WEST SUSSEX COUNTY COUNCIL CONSULTATION

TO:	Arun District Council FAO: Michael Eastham
FROM:	Stephen Gee WSCC - Highways Authority
DATE:	11 January 2021
LOCATION:	Land at Ford Road Arundel
SUBJECT:	AB/135/20/OUT Outline application with some matters reserved (except for access) for the development of 90 dwellings & associated amenity land. This application is a Departure from the Development Plan, affects the setting of listed buildings & affects the character & appearance of the Arundel Conservation Area.
DATE OF SITE VISIT:	n/a
RECOMMENDATION:	More Information
S106 CONTRIBUTION TOTAL:	n/a

Plate 2.2: WSCC Proposed Cycle Routes (red lines)

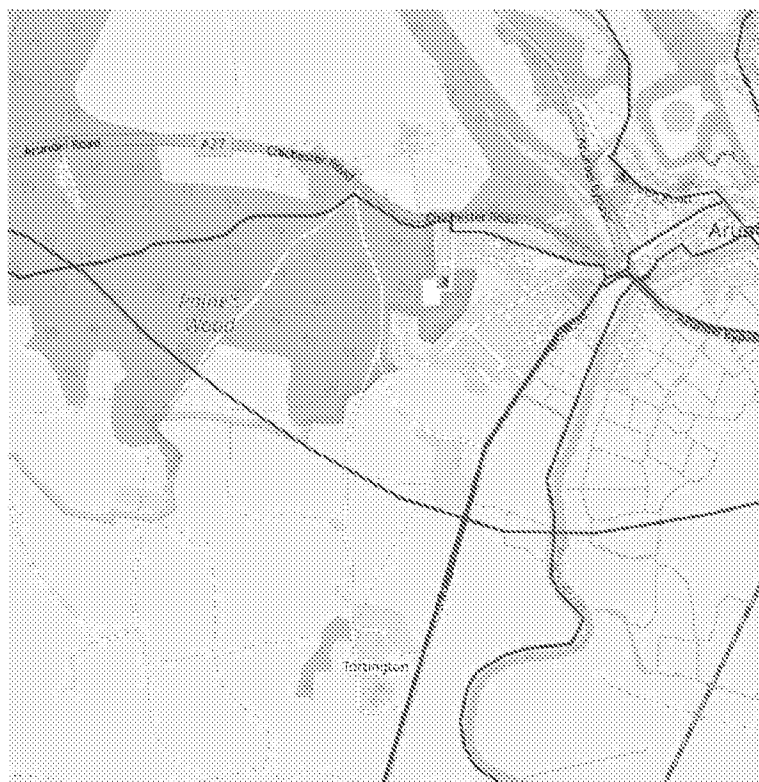
The Transport Assessment notes the WSCC walking and cycling strategy and the future route proposals within the vicinity of the site. One of the routes identified is a on off road shared path between Arundel and Ford Station, no information has been provided within the application to identify how the site could help deliver the proposals.

Details of pedestrian connectivity/identification of ped infrastructure improvements /pedestrian visibility splays.
Details of how the site would support the provision of future off road cycle route provision between Ford and Arundel.

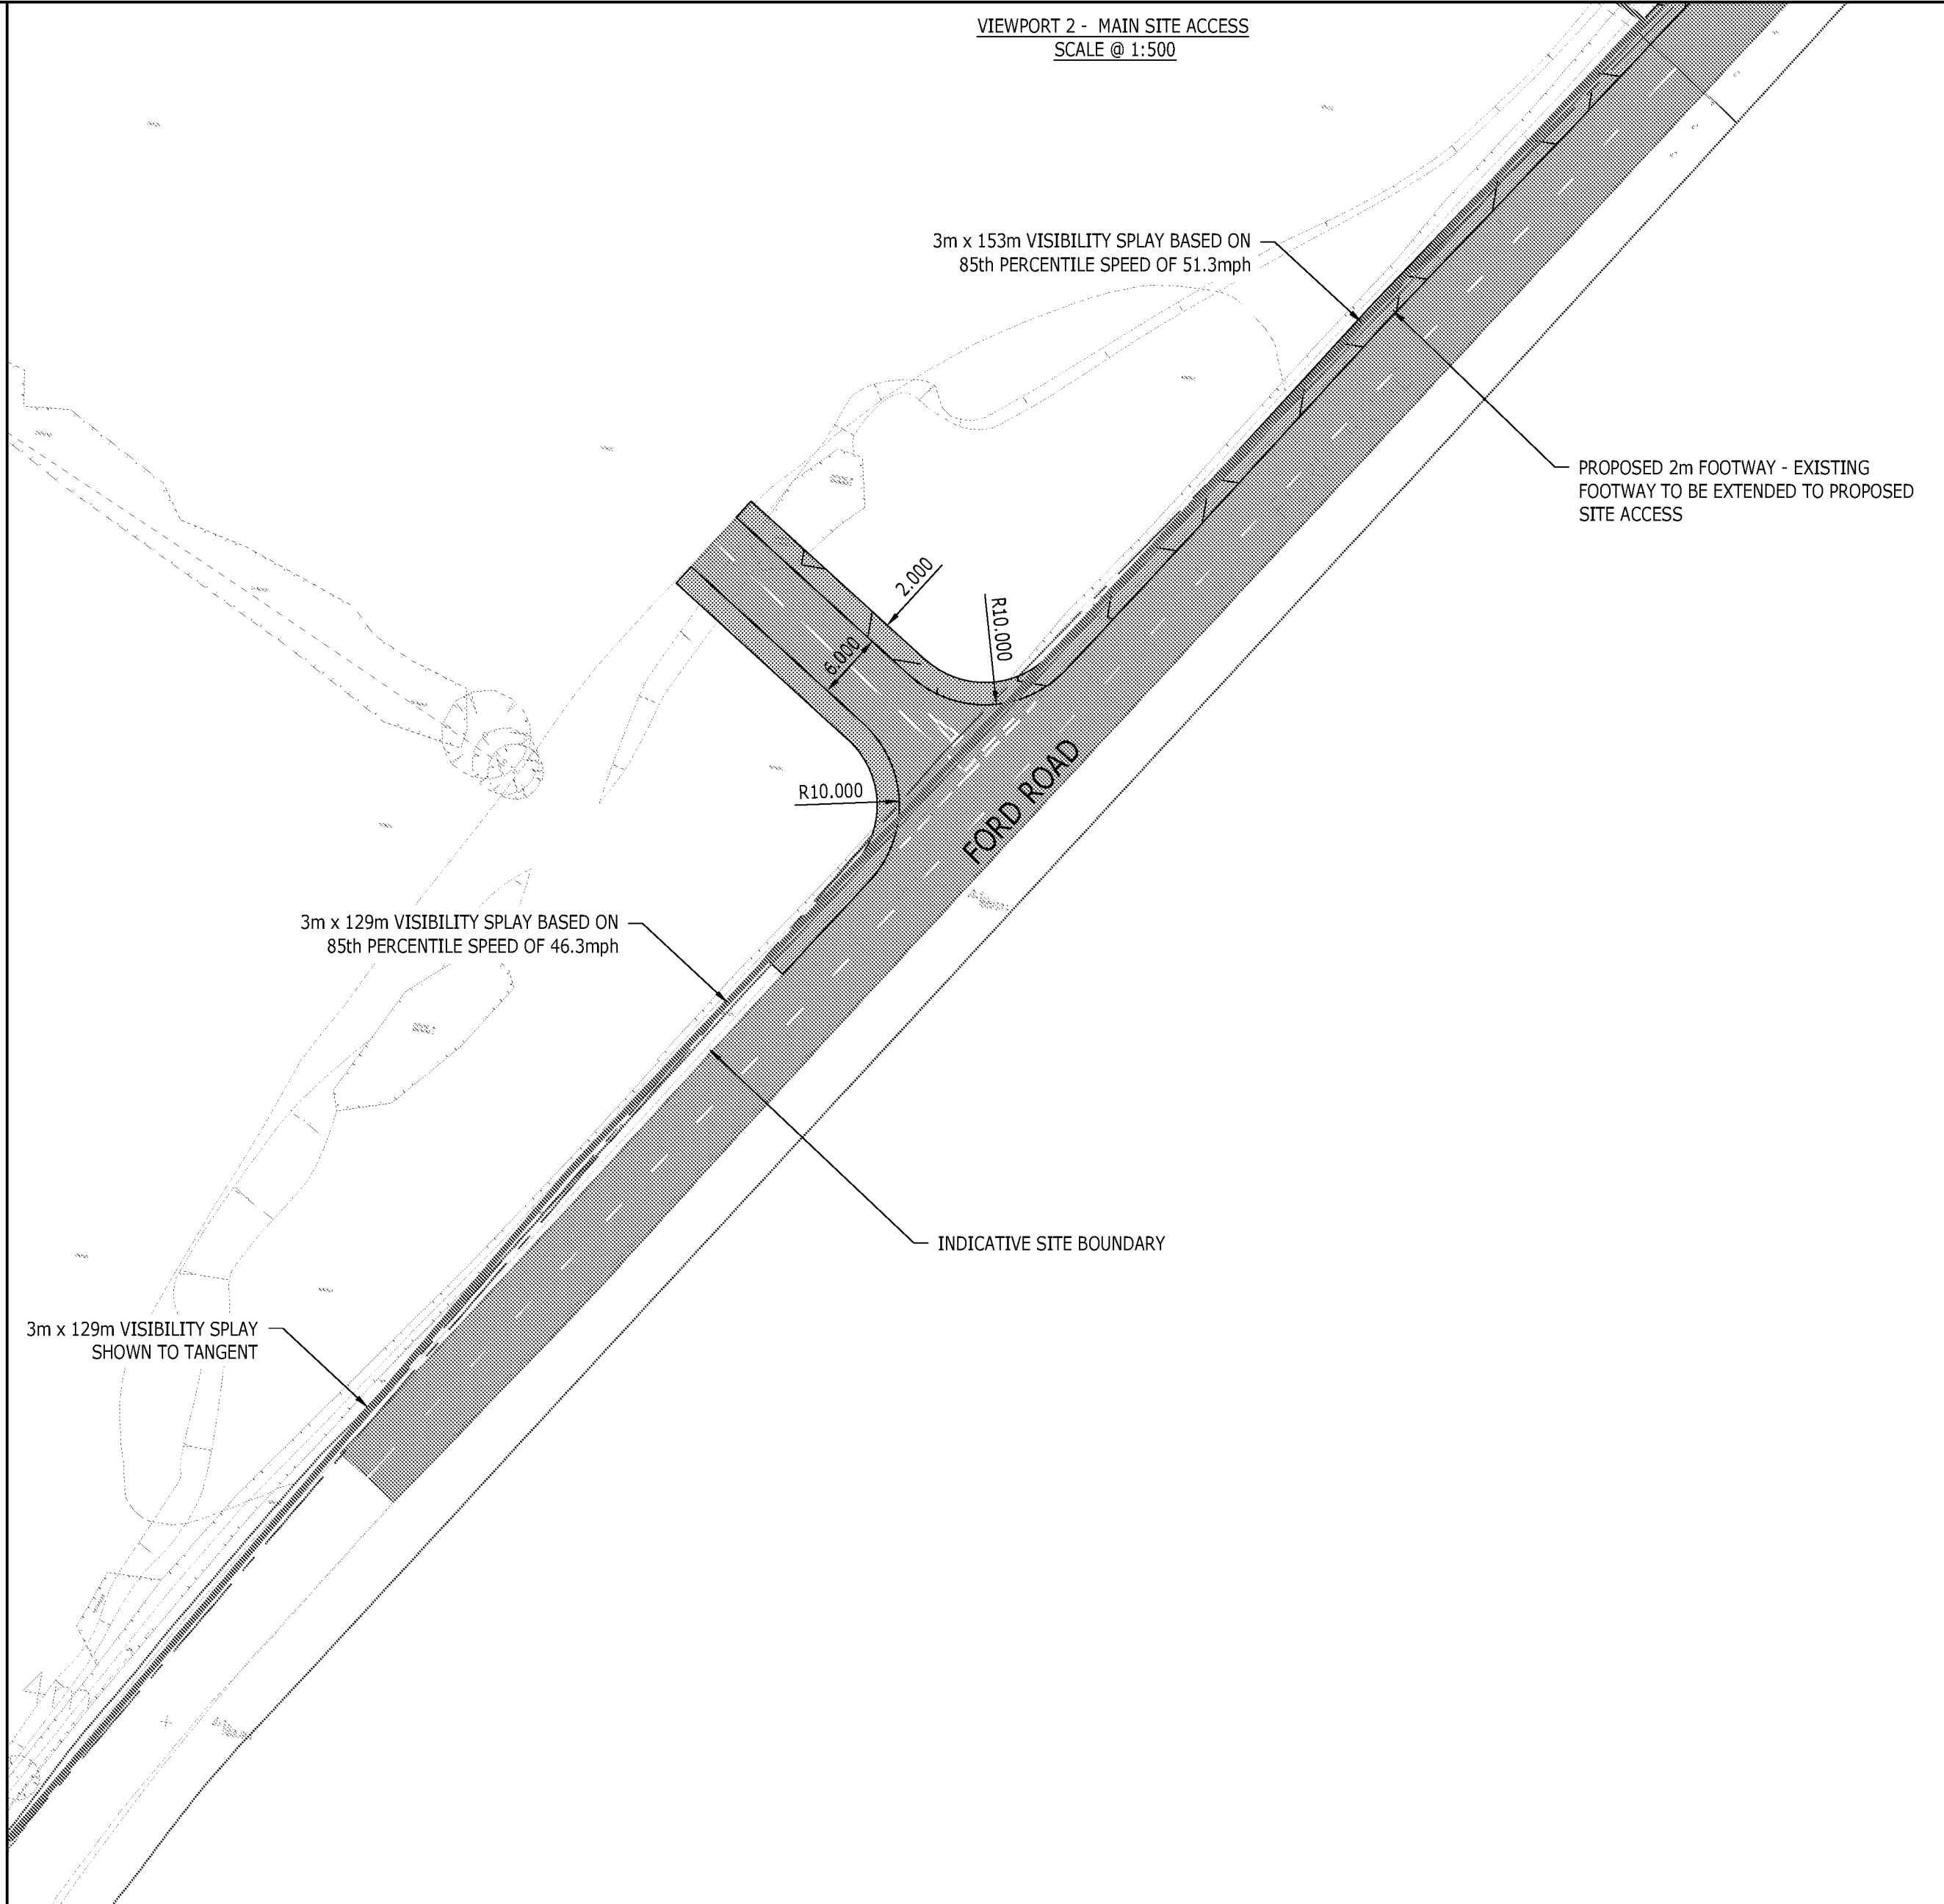
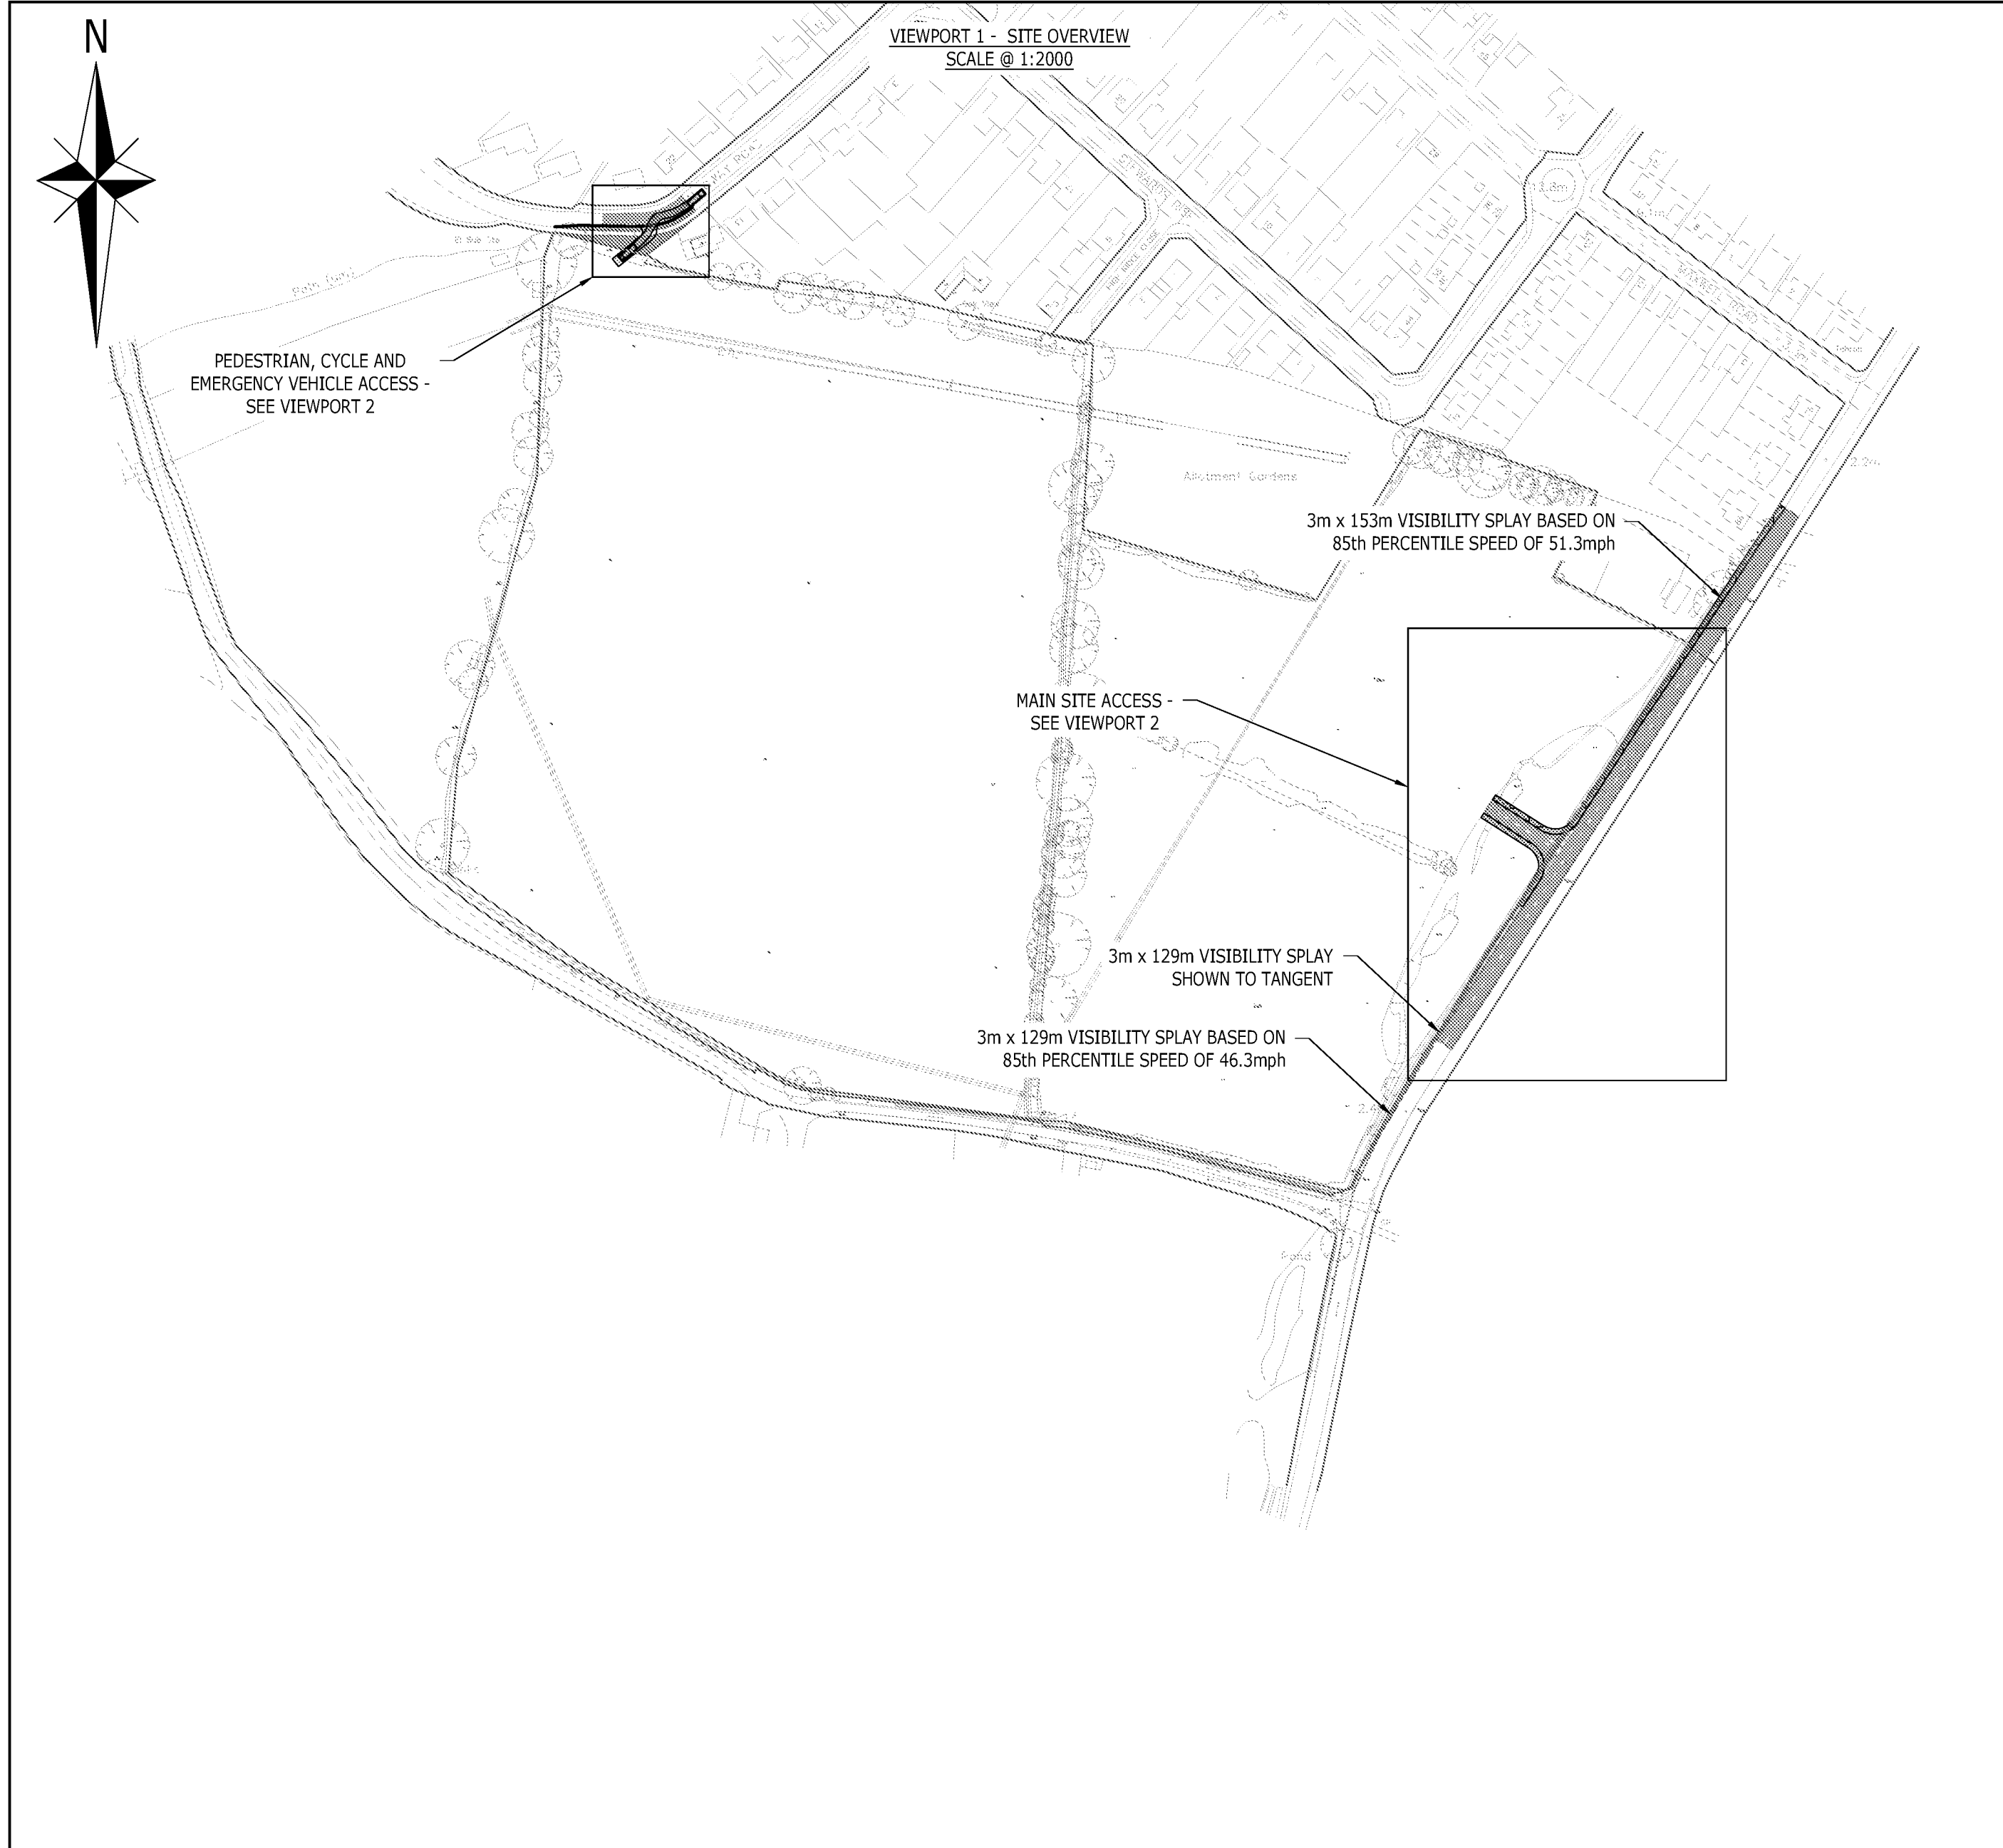
The application proposes a simple priority junction with an carriageway width of 6m and radii of 10m. Visibility splays are provided in line with DMRB parameters of 3m x 129m to the south and 3mx 153m to the north.

A stage 1 Road Safety Audit has been undertaken and did not highlight any issues.
